27 August 2020

Boral Land & Property Group

**SUBMISSION ON STATE SIGNIFICANT DEVELOPMENT - NEW BRICKWORKS FACILITY
SSD-10422 - WINGECARRIBEE SHIRE**

Figure 4: Berrima Road Deviation Project

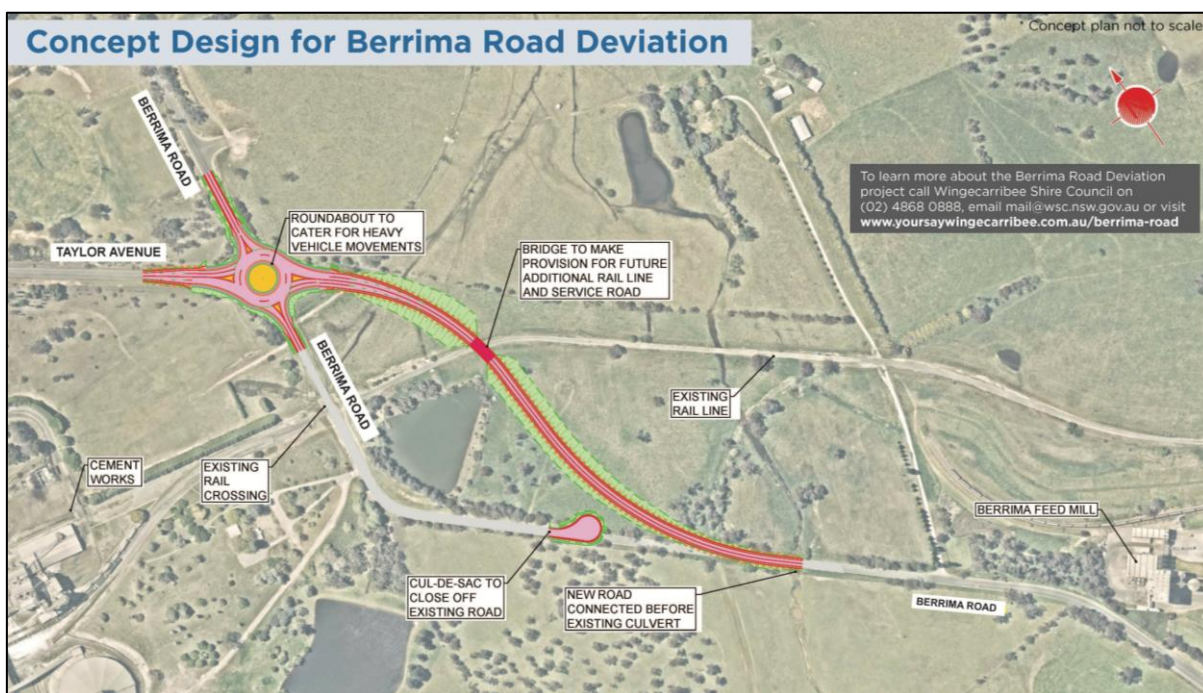
The assessment fails to take into account the proposed Berrima Road Deviation project, and only appears to have modelled the existing mound partially constructed directly to the south of the existing Boral Rail line, as illustrated below.

By failing to consider the Berrima Road deviation project in its entirety, the flood modelling has not appropriately considered the potential impacts the establishment of the new development pad will have on flood activity, and effects to Boral's rail line. The Berrima Road Deviation is illustrated in the following image:

Should flood impacts on the rail line change as a result of the proposal, appropriate mitigation measures must be implemented to ensure that rail line servicing the Cement Works, is not detrimentally impacted from either an operational or structural integrity perspective.
